Project Title: EAST CENTURY GATEWAY PLAZA	Building Permit #:	City Drainage #: K20-D061
DRB#: EPC#:		Work Order#:
Legal Description: LOTS 1-3 EAST CENTURY GATEWAY PLAZA		
City Address: 10201 CENTRAL NE		
		Contact: DAVID SOULE
Engineering Firm: RIO GRANDE ENGINEERING		
Address: PO BOX 93924, ALBUQUERQUE, NM 87199 Phone#: 505.321.9099 Fax#: 505.8	72.0999	E-mail: DAVID@RIOGRANDEENGINEERING.COM
Phone#: 505.321.9099 Fax#: 505.8		
Owner: TEKIN PROPERTIES		Contact:
Address: 8036 OAK POINT DRIVE, FRISCO, TEXAS 75034		,,,,,,,,,,,,,,,,,,,,,,,,,,,,,,,,,,,,,,
Phone#: Fax#:		E-mail:
Architect: PETER BUTTERFIELD		Contact: PETER BUTTERFIELD
Address: Phone#: Fax#:		E-mail:
Phone#:		
Surveyor: SURV-TEK	<u> </u>	Contact: rUSTY hUGG
Address:		
Phone#: 9 Fax#:	,	E-mail:
Contractor:		Contact:
Address:		
Phone#:		E-mail:
	CHECK TVPE OF APPROV	VAL/ACCEPTANCE SOUGHT:
TYPE OF SUBMITTAL:	SIA/FINANCIAL GUARAN	
DRAINAGE REPORT	PRELIMINARY PLAT API

Re: East Century Gateway Plaza Tract 2

RE: East Century Gateway Plaza
Grading and Drainage Plan
Engineers Stamp Date 6/20/14 (K20-D061)

RE: East Century Gateway Plaza
Grading and Drainage Plan
Engineers Stamp Date 6/11/14 (K20-D061)

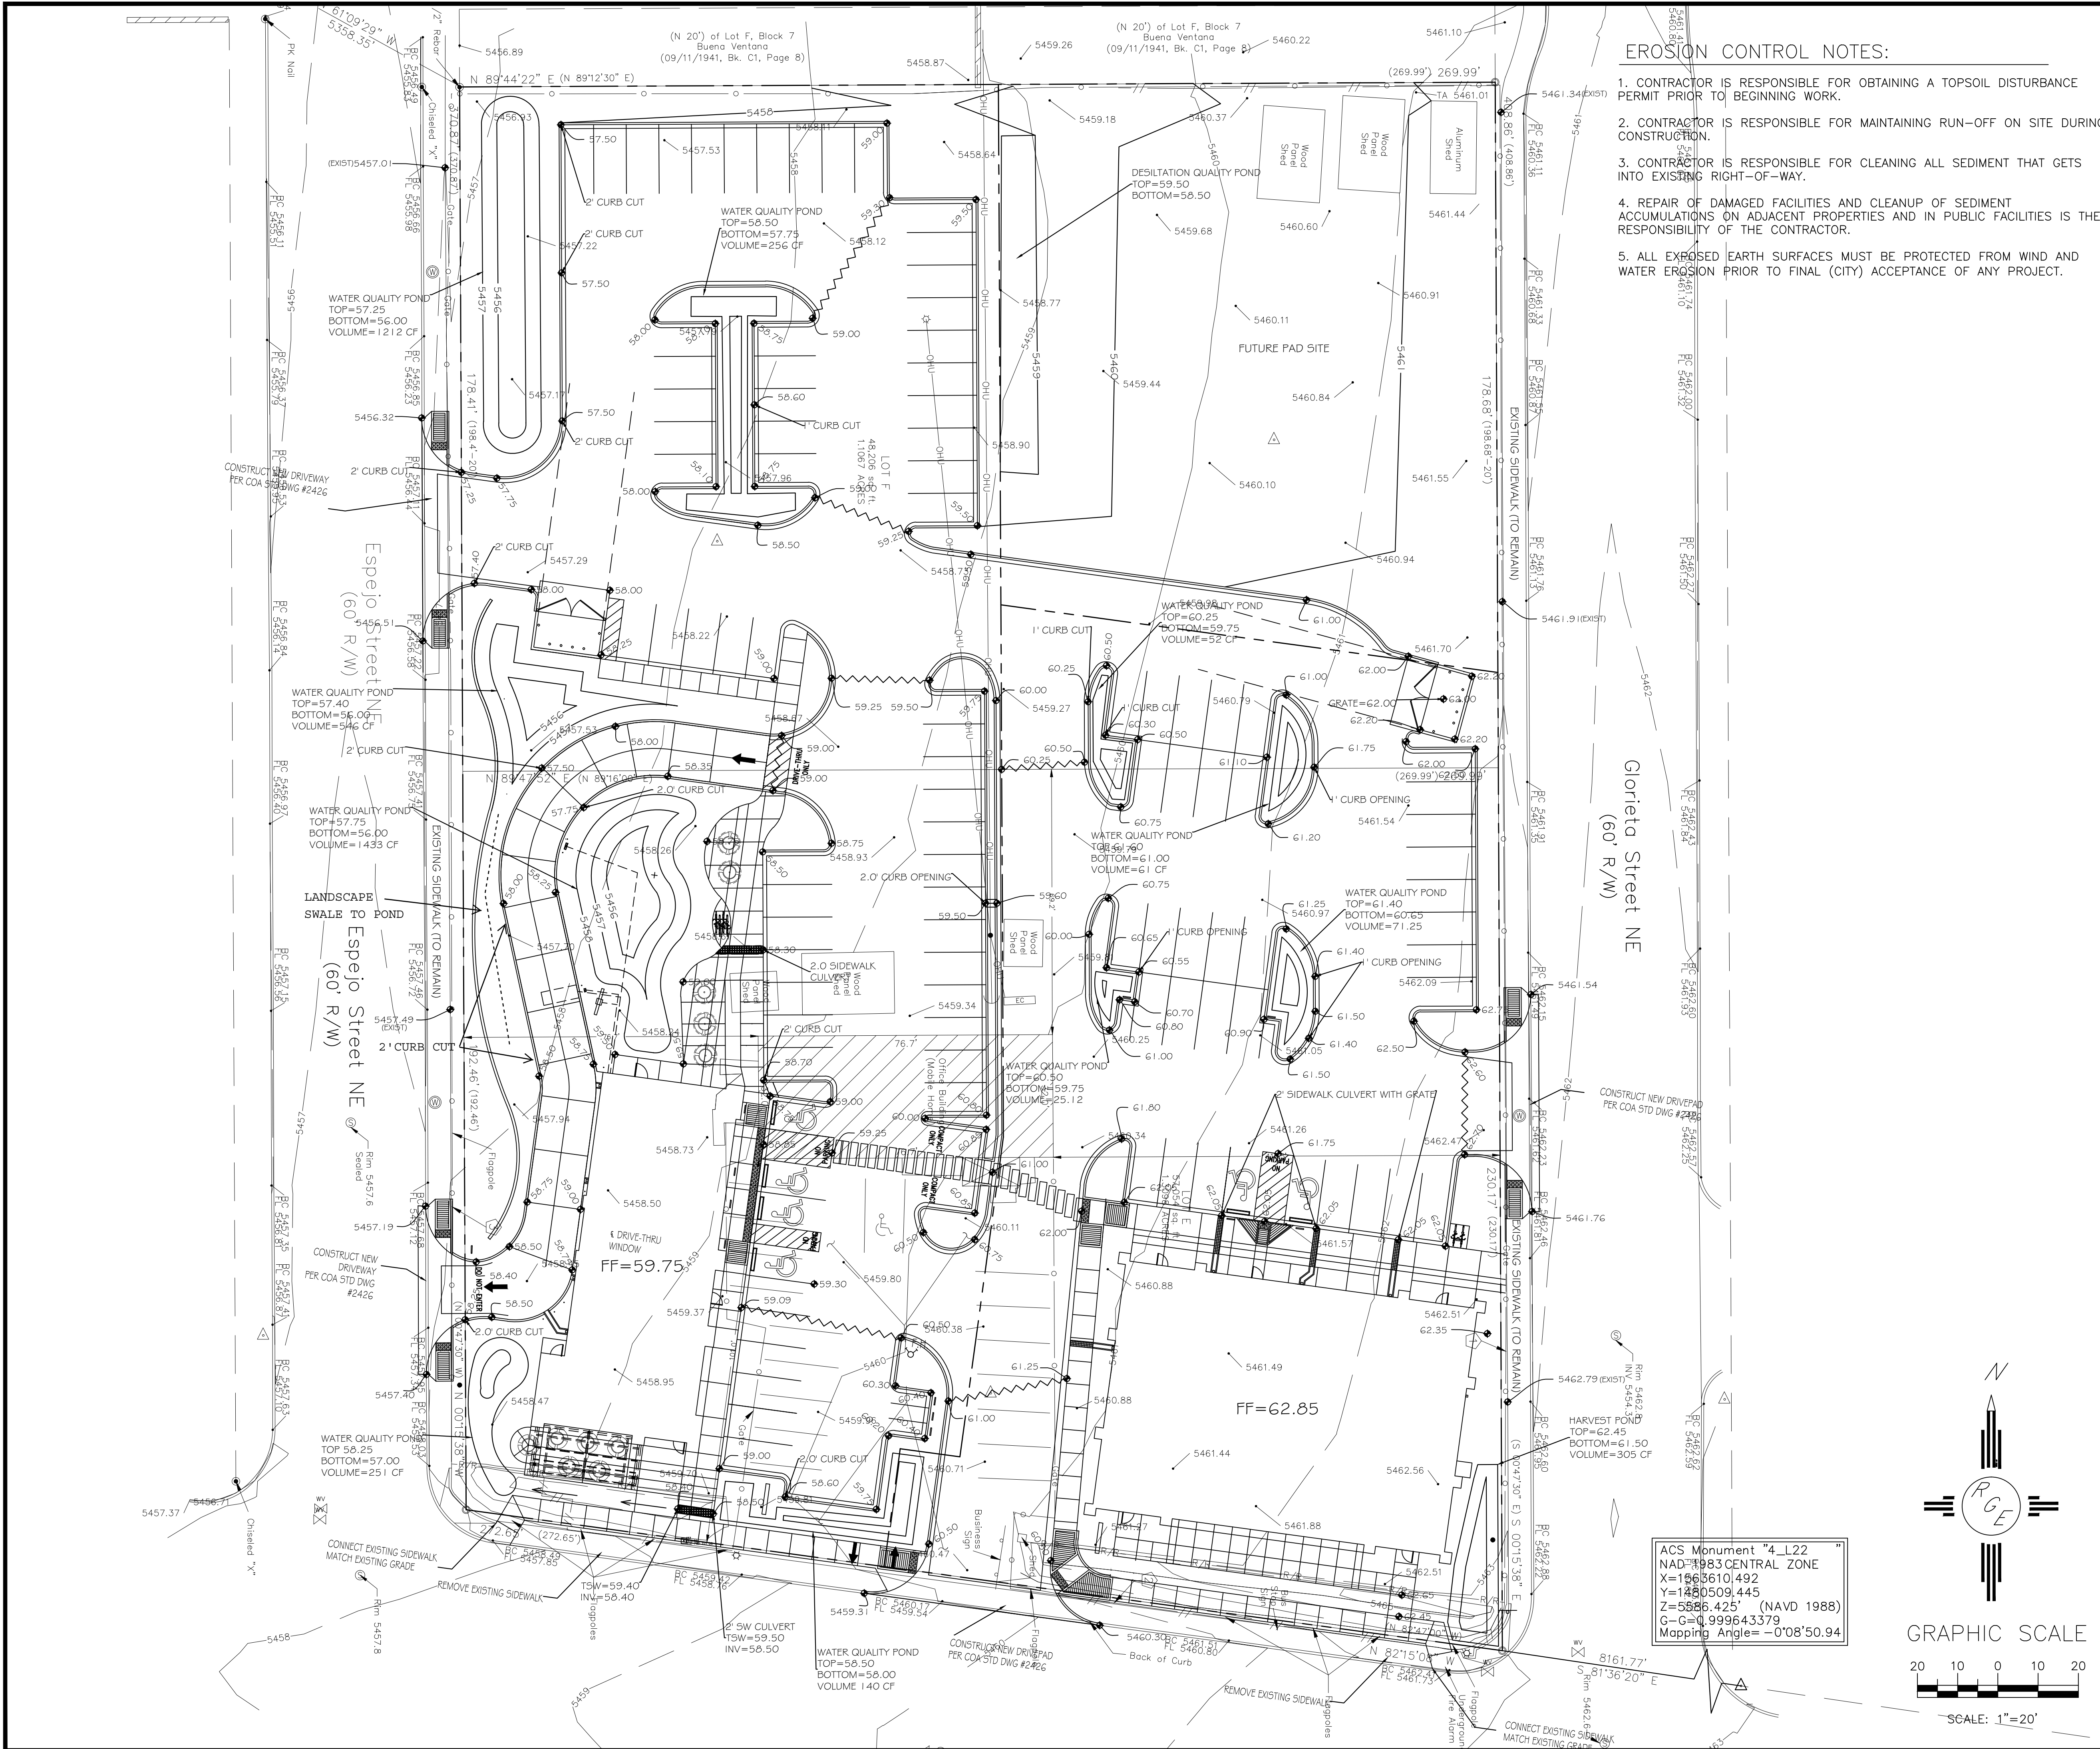
- A drain with a grease trap needs to be placed in the trash enclosure.
- Add two foot curb cuts spaced every 20 feet in the drive thru lane.

Added a note to the plan stating this requirement. I have included a reduced copy of the master utility plan to show we will be constructing this feature
- 2. Add two foot curb cuts at drive thru lane.

We have added two additional curb cuts to the drive thru lane. The lane was designed to have a 1% slope to a single opening, the additional cuts improve the design

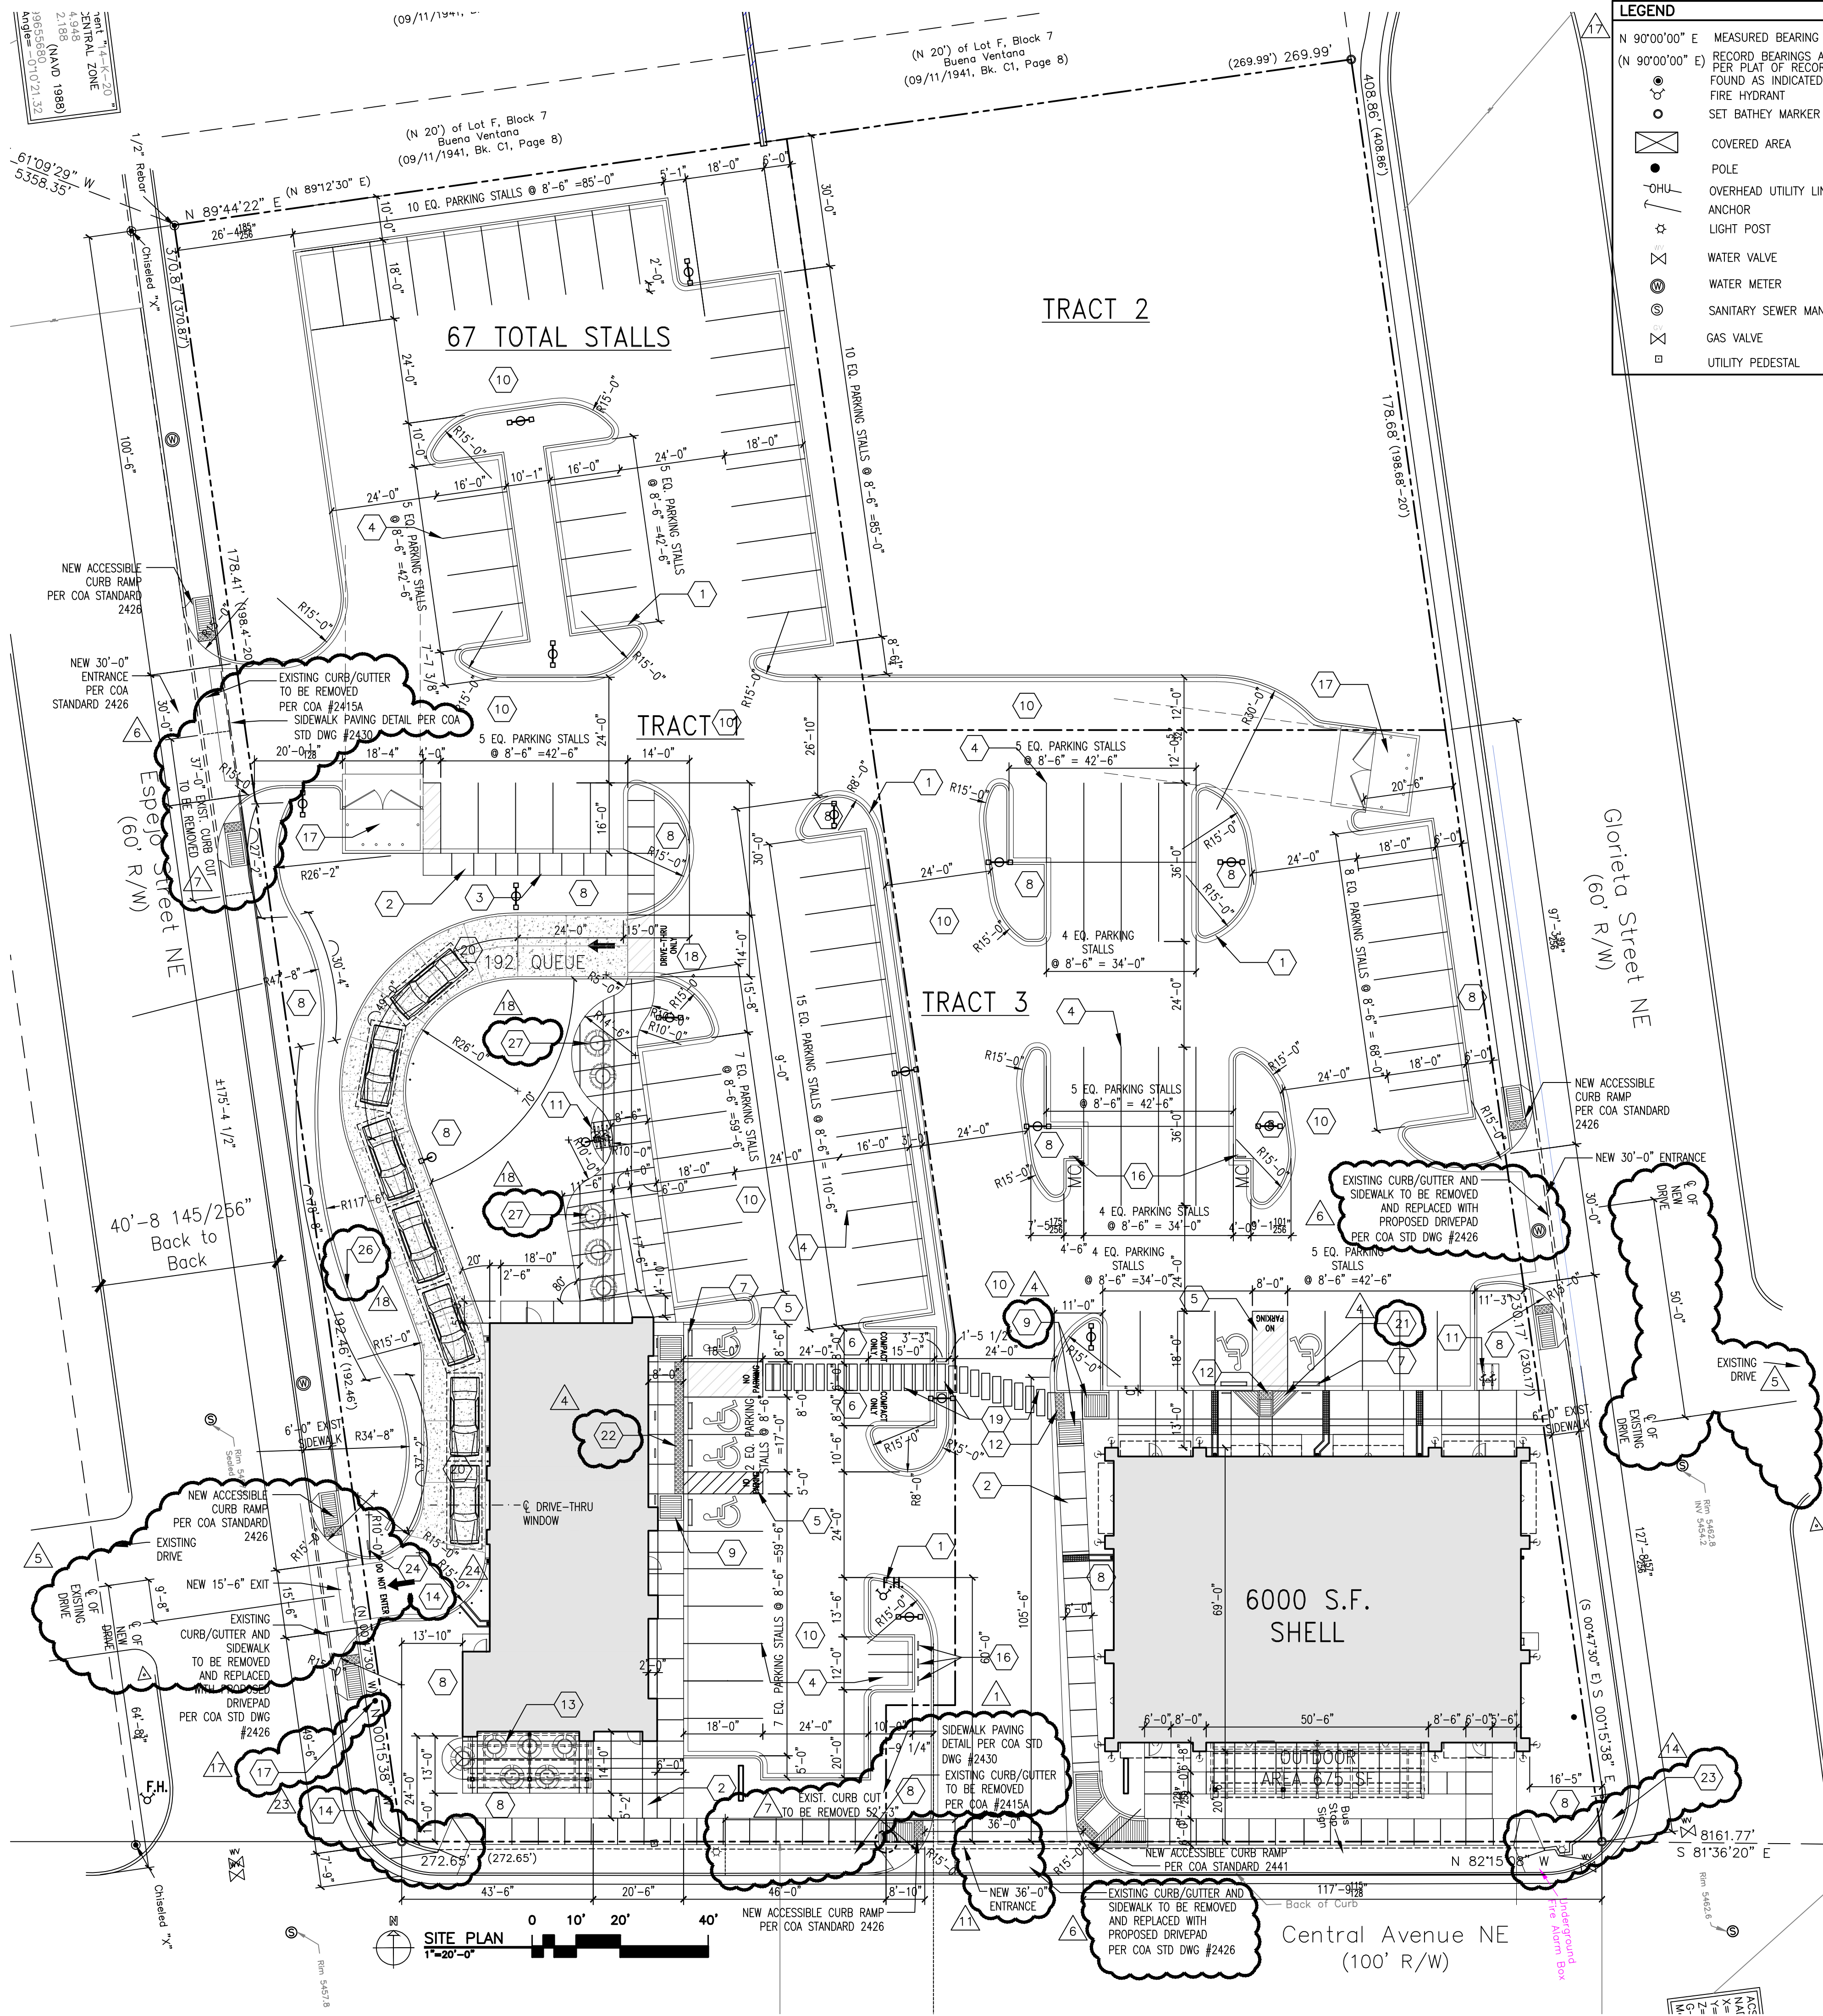
- The corner curb ramp at Central Ave and Espejo St NE needs to be removed and replaced per the City of Albuquerque Standard Specifications drawing 2426 to comply with ADA access.
- All wheel chair ramps located within the public right of way must have truncated domes. The wheel chair ramp on the corner of Central Ave and Espejo St NE is missing the truncated domes.

I am following up with you in regards to a request from Mr. Rick Gonzales from Hart Construction in reference a ramp we had to remove and replace during the installation of a new service line to the new Freddy's Restaurant at 10201 Central Ave NE. The existing main was located under the ramp and needed to be removed and replaced by NMGC to complete the installation of the requested service. The ramp was replaced to where we did not change to original slope of the ramp.
